STATE OF NORTH CAROLINA
DEPARTMENT OF TRANSPORTATION

Addendum No. 1

RE: Contract # C204076
WBS # 38389.3.3
F. A. # BRSTP-0059(005)
Cumberland County (B-4491)
Bridge #22 Over I-95 Business/US-301 On NC-59

March 20, 2018 Letting

T.I.P. NO.	SHEET NO.
<b>B-4491</b>	<b>UO-1</b>

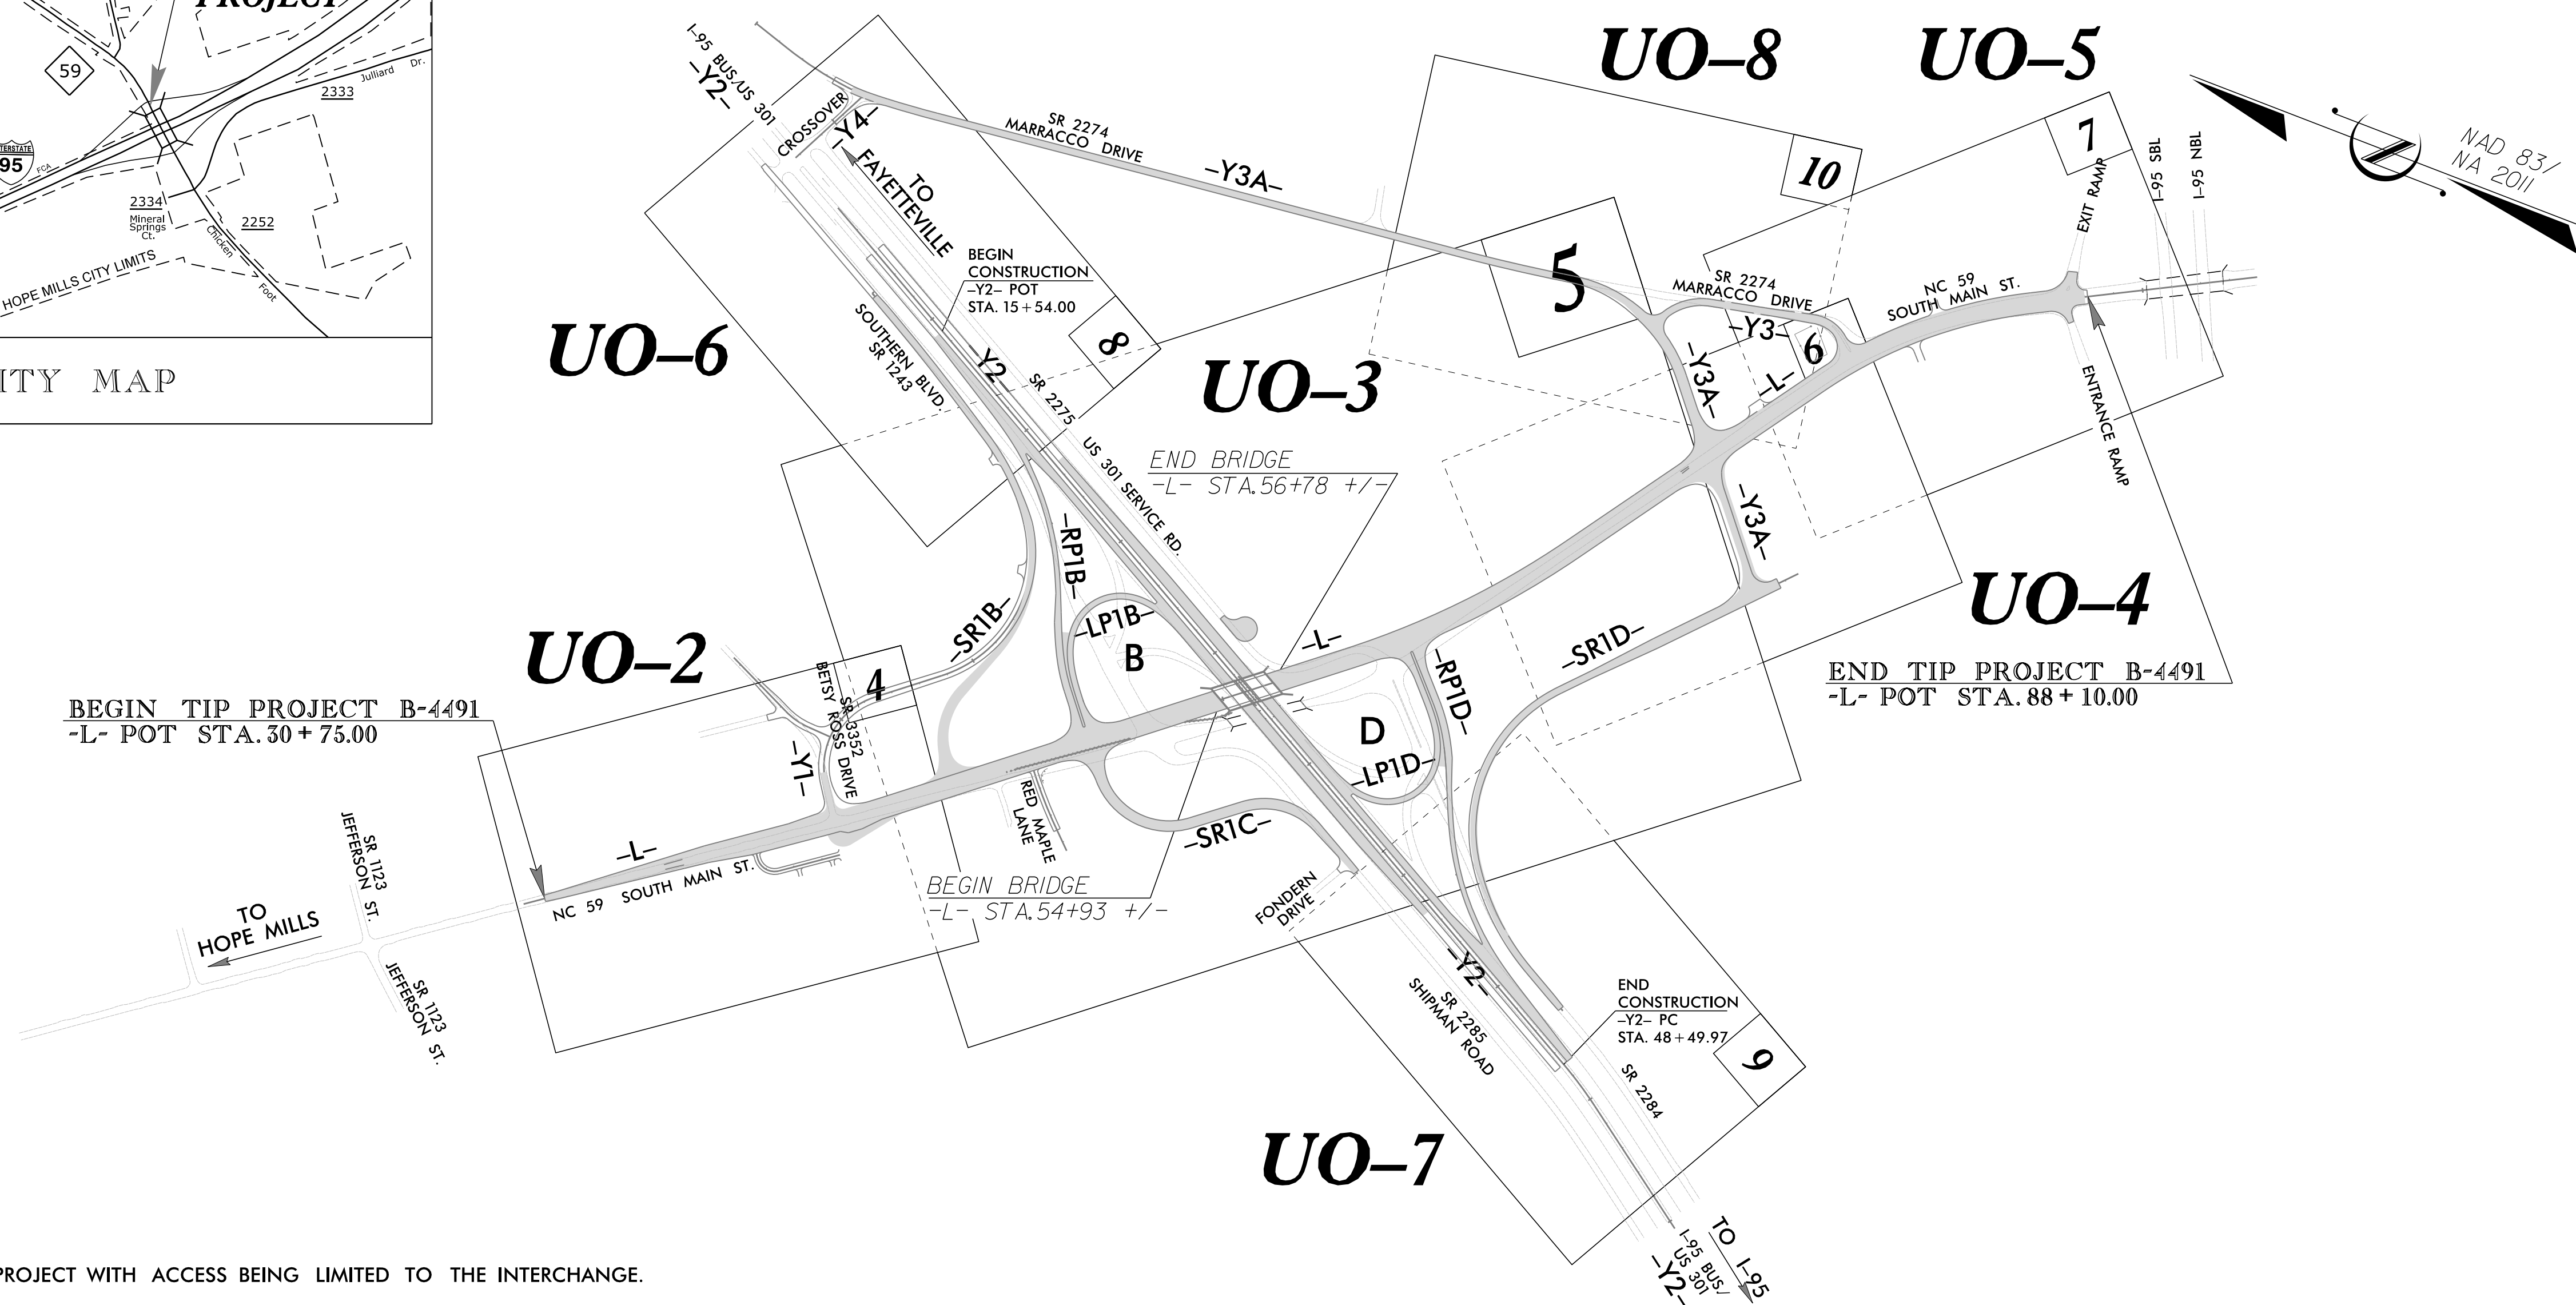
Sheet No.	Revisions
UO-1	Revised the list of Utility Owners
U0-2 thru UO-8	Revised to label the Utility Owners names
